From: Laura Gibbons
Sent: 08 September 2020 12:01
To: Planning.Responses
Cc: Simon Davis
Subject: BE/79/20/RES The Cottage Shripney

Engineers Comments Regarding Surface Water Drainage

Site Plan -
Proposed

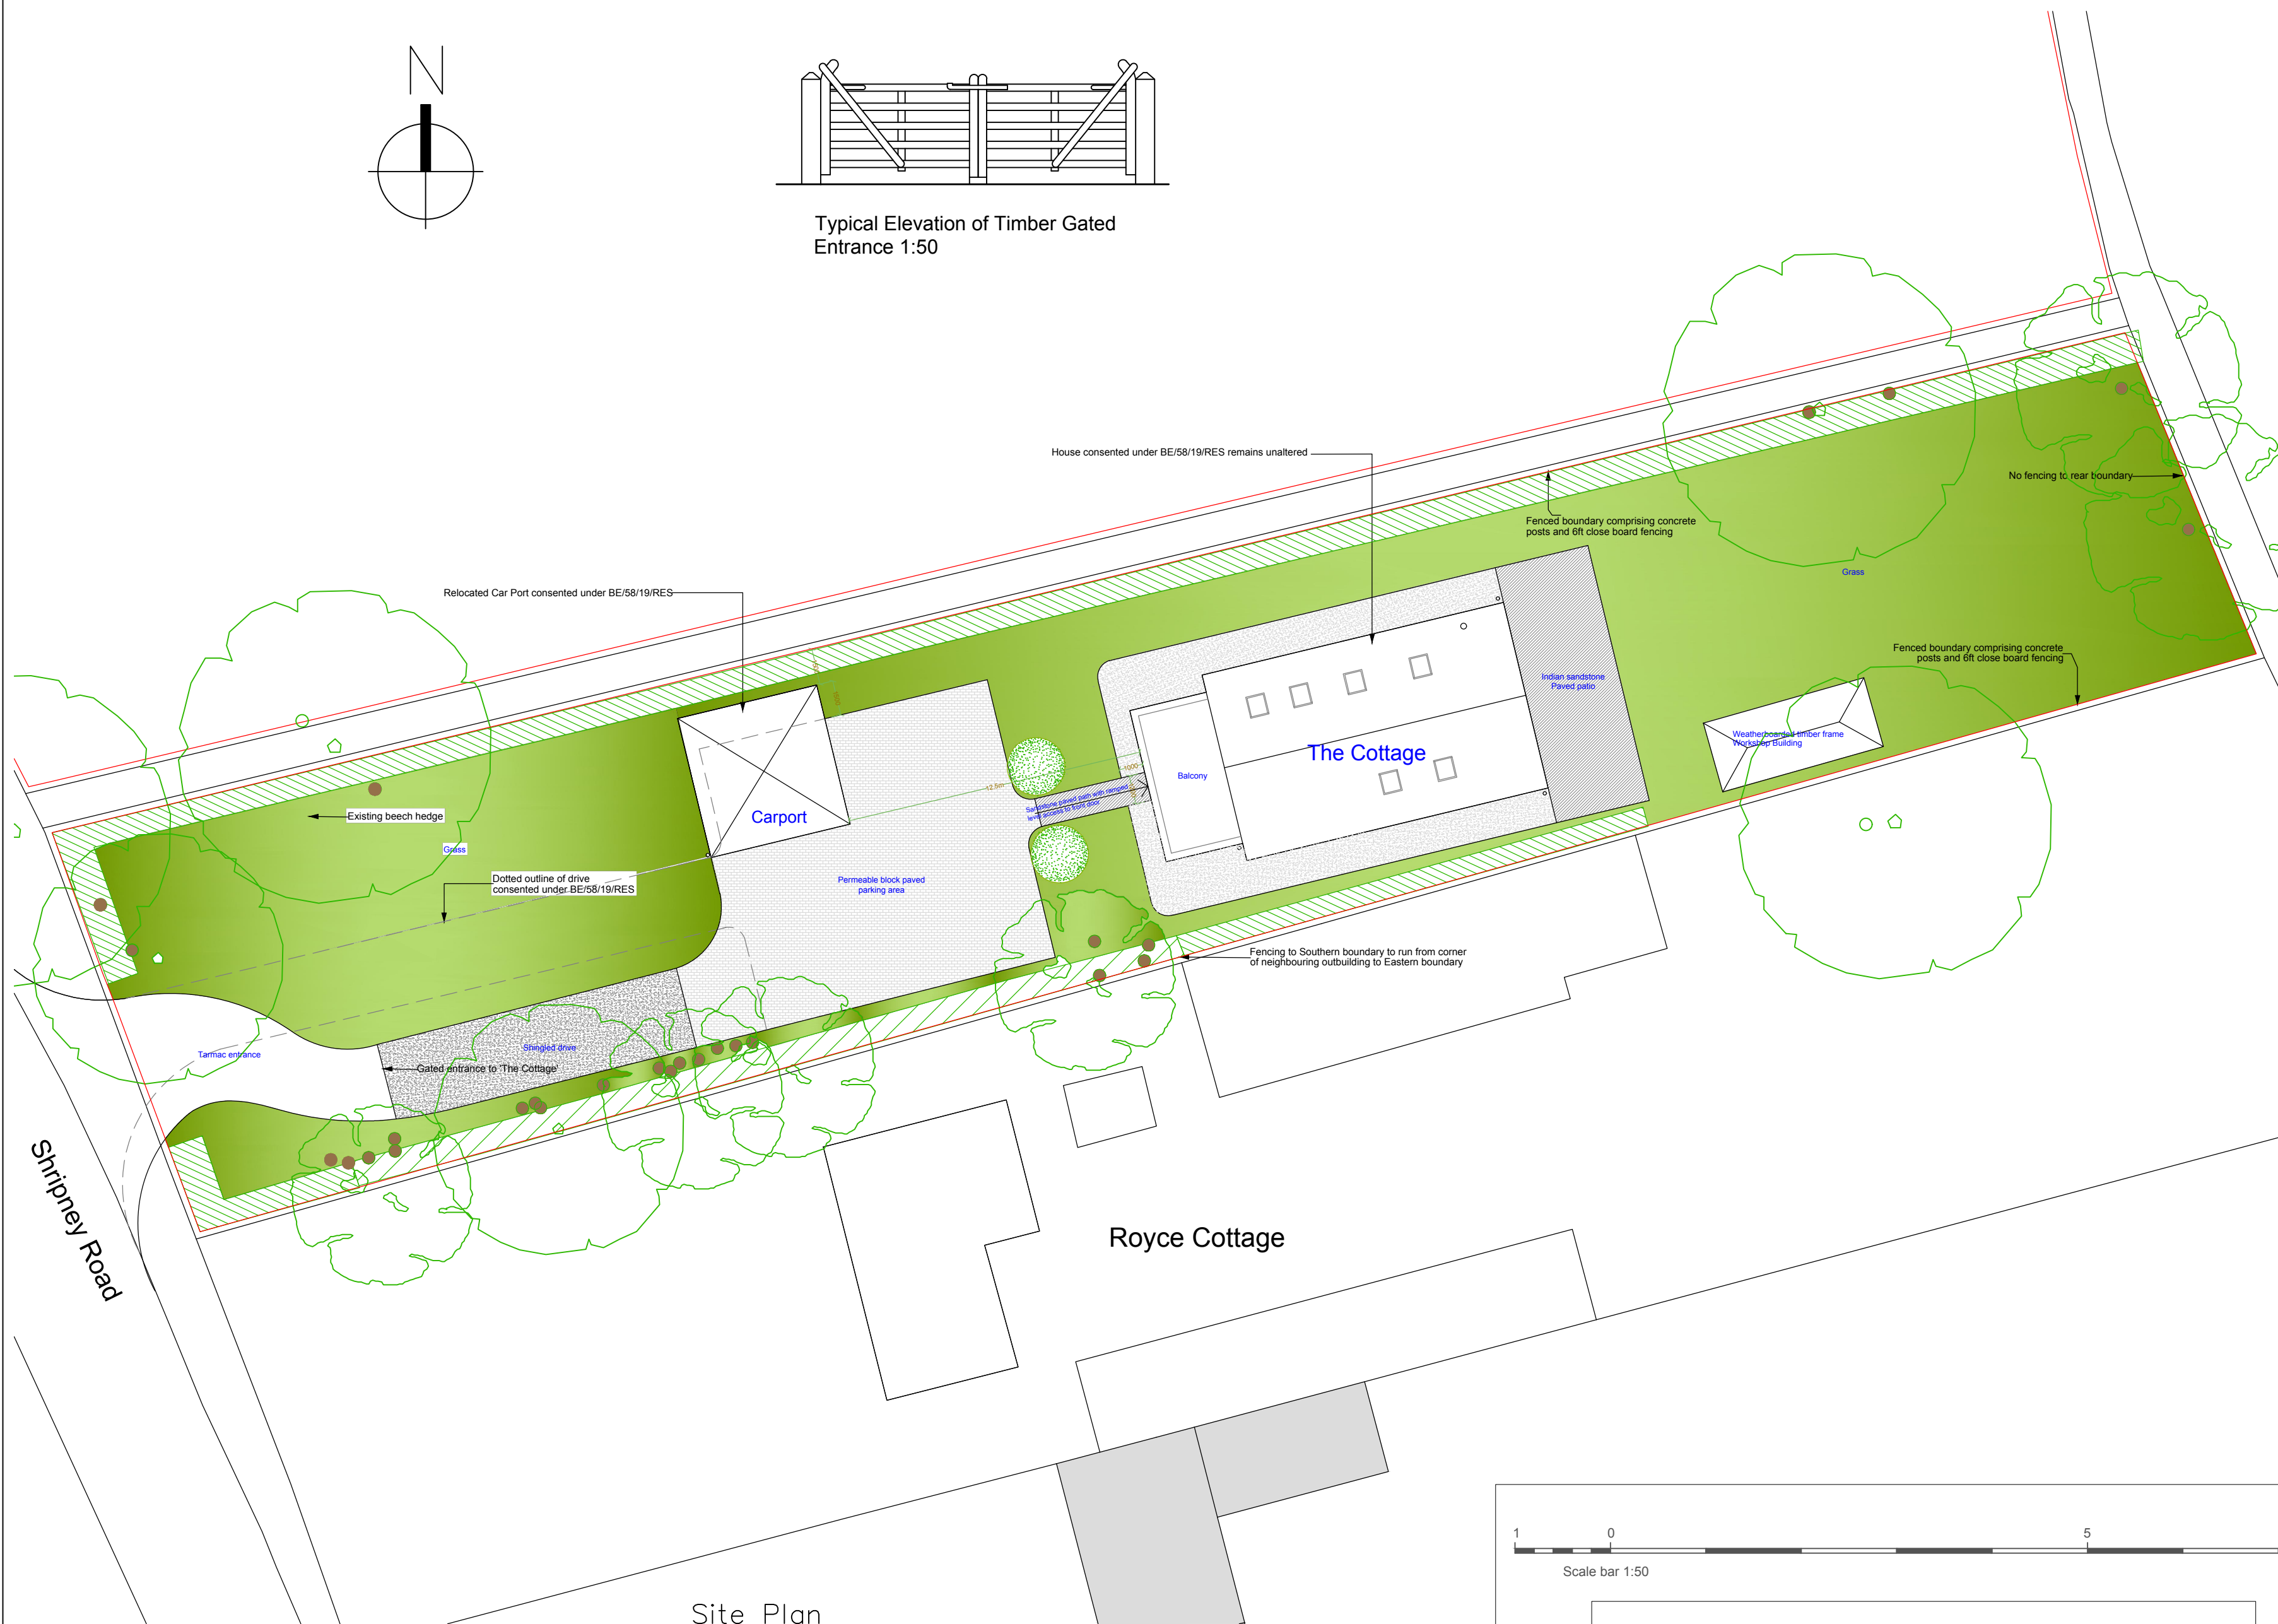
If a culvert is found along Shripney Road when forming the access way we should be contacted immediately.
